CITY OF ALBUQUERQUE

July 10, 2023

Re: Fiesta Subaru
7100 Lomas Blvd. NE
30-Day Temporary Certificate of Occupancy
Transportation Development Final Inspection
Architect's Stamp dated 4-28-22 (K19D108A)
Certification dated 6-30-23

A1 SITE PLAN

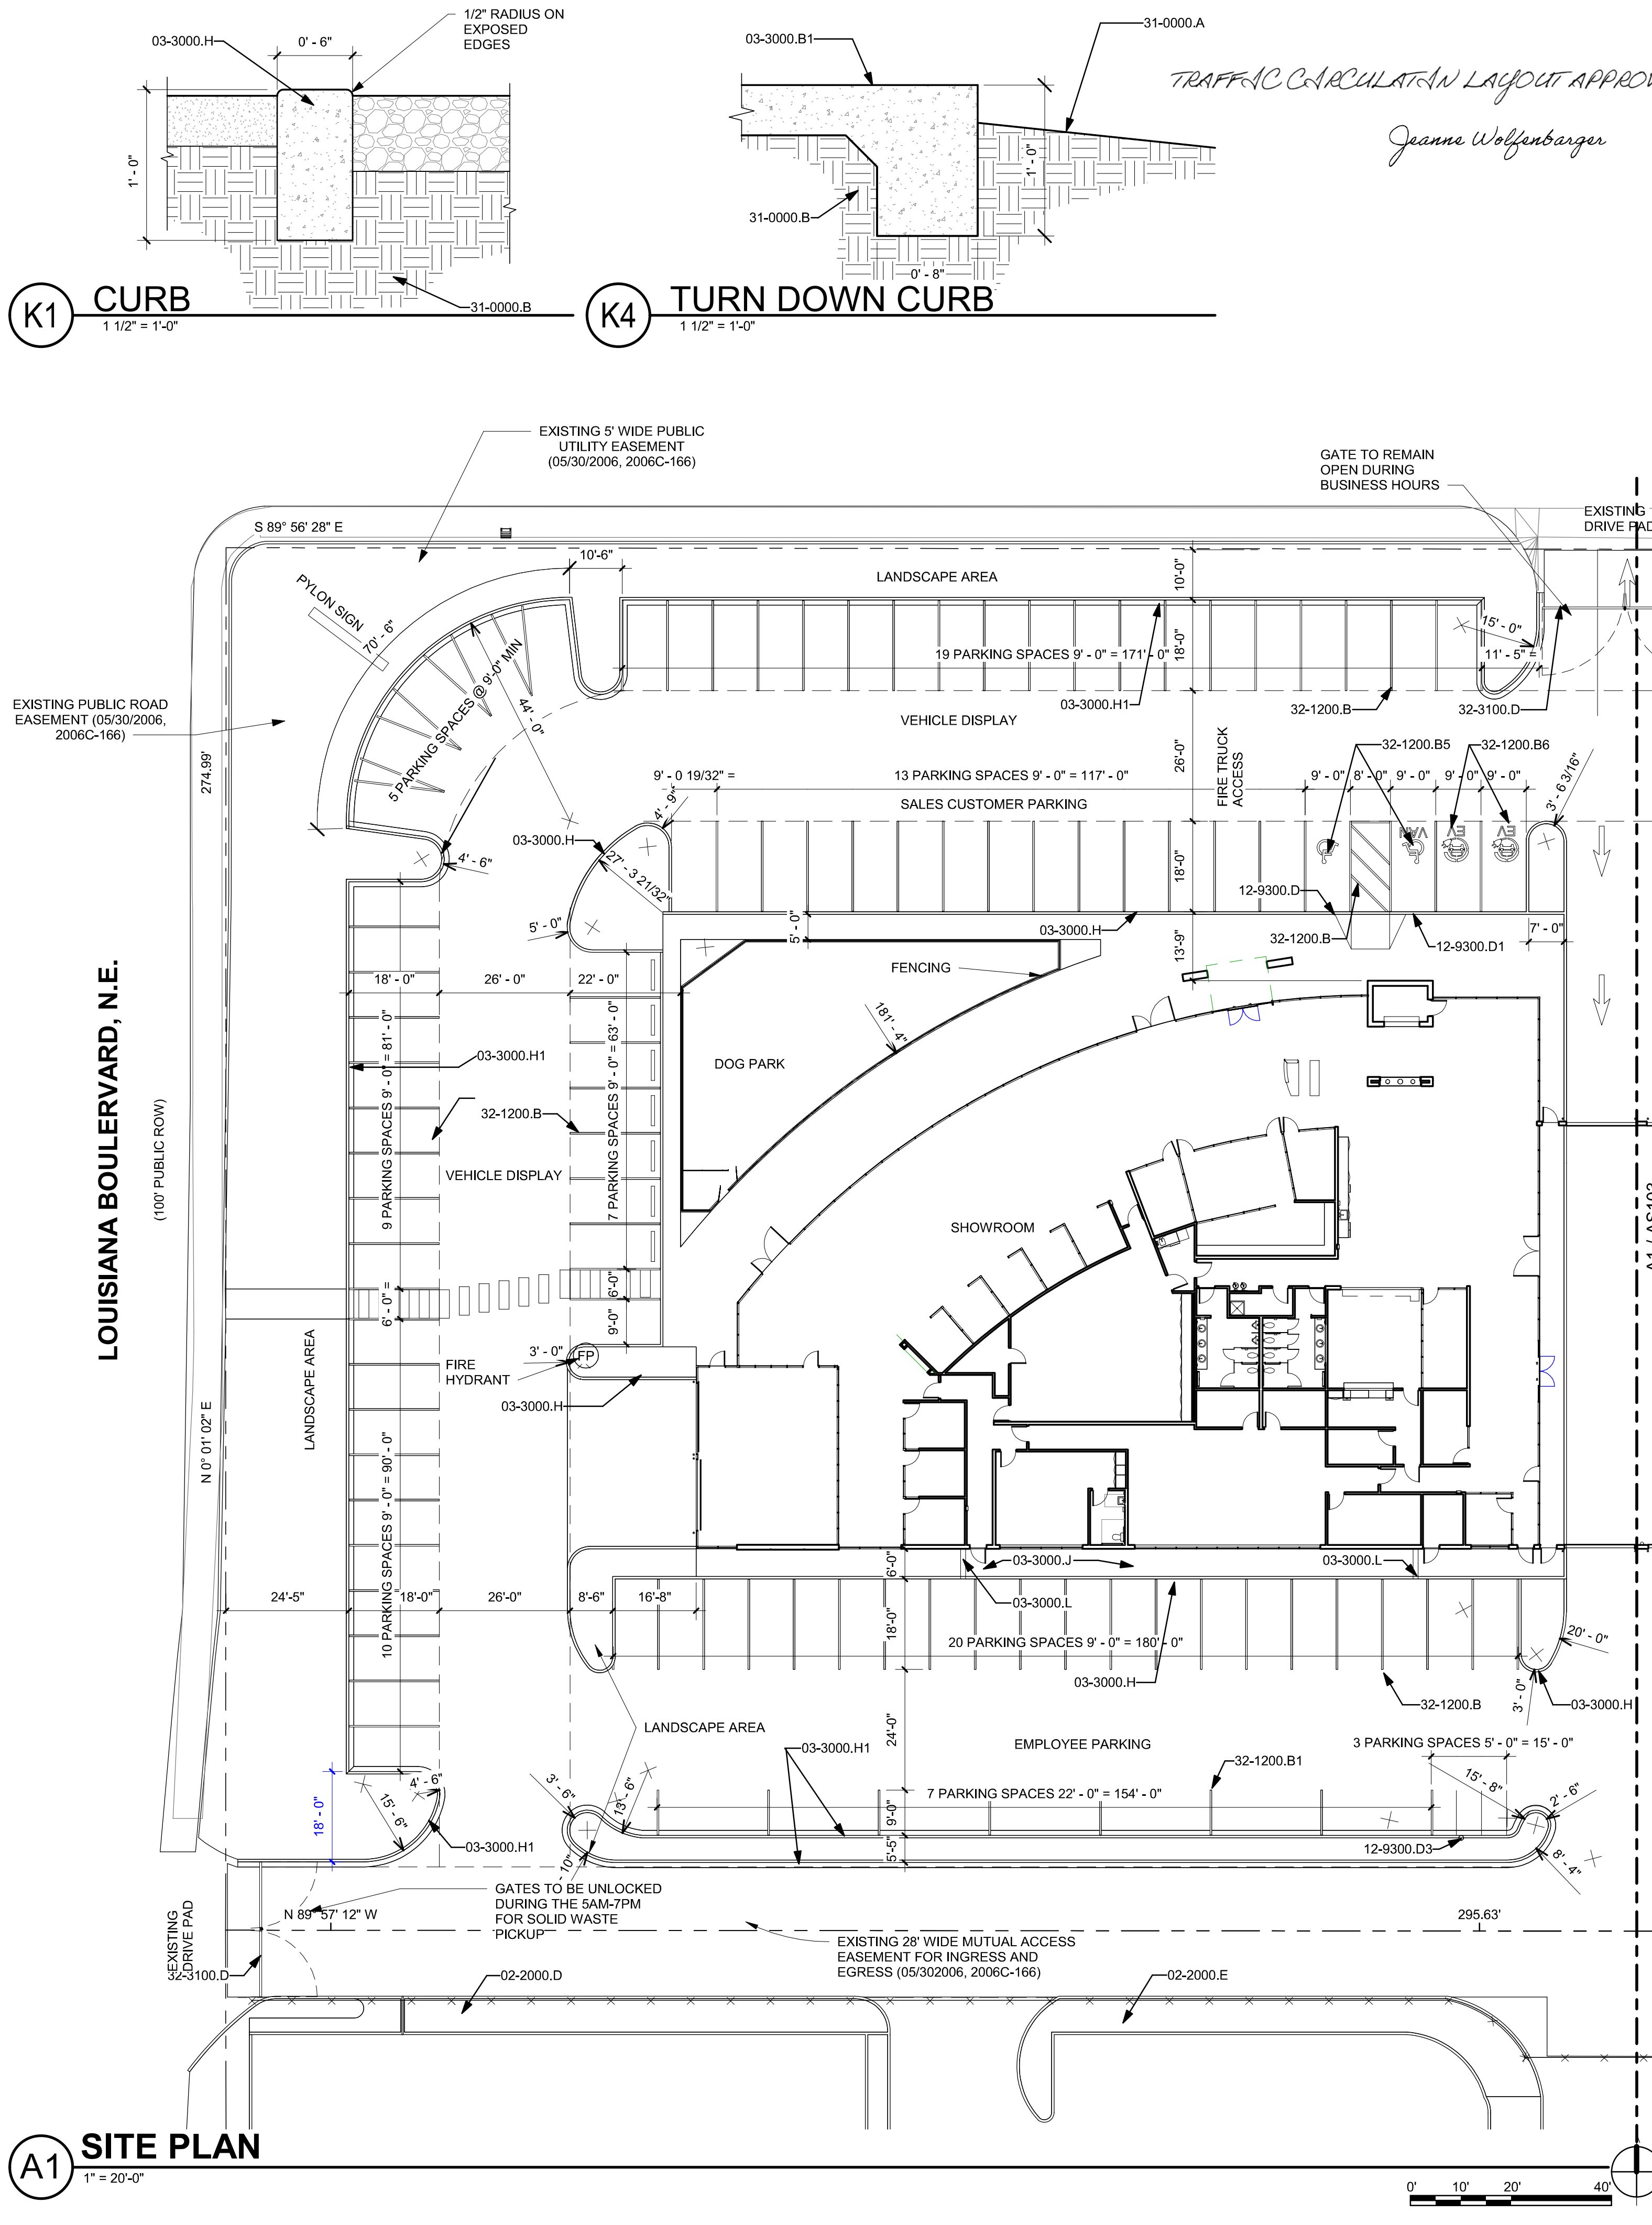
- All sight work must be completed. Some parking striping was still in progress and there were large piles of gravel for landscaping purposes in the parking lot.
- Per approved site plan, please provide an ADA pathway connection in the southwest entrance. Either reconstruct to add accessible ramps the same as the other entrances or add an ADA accessible path along the back of the drive ramp.
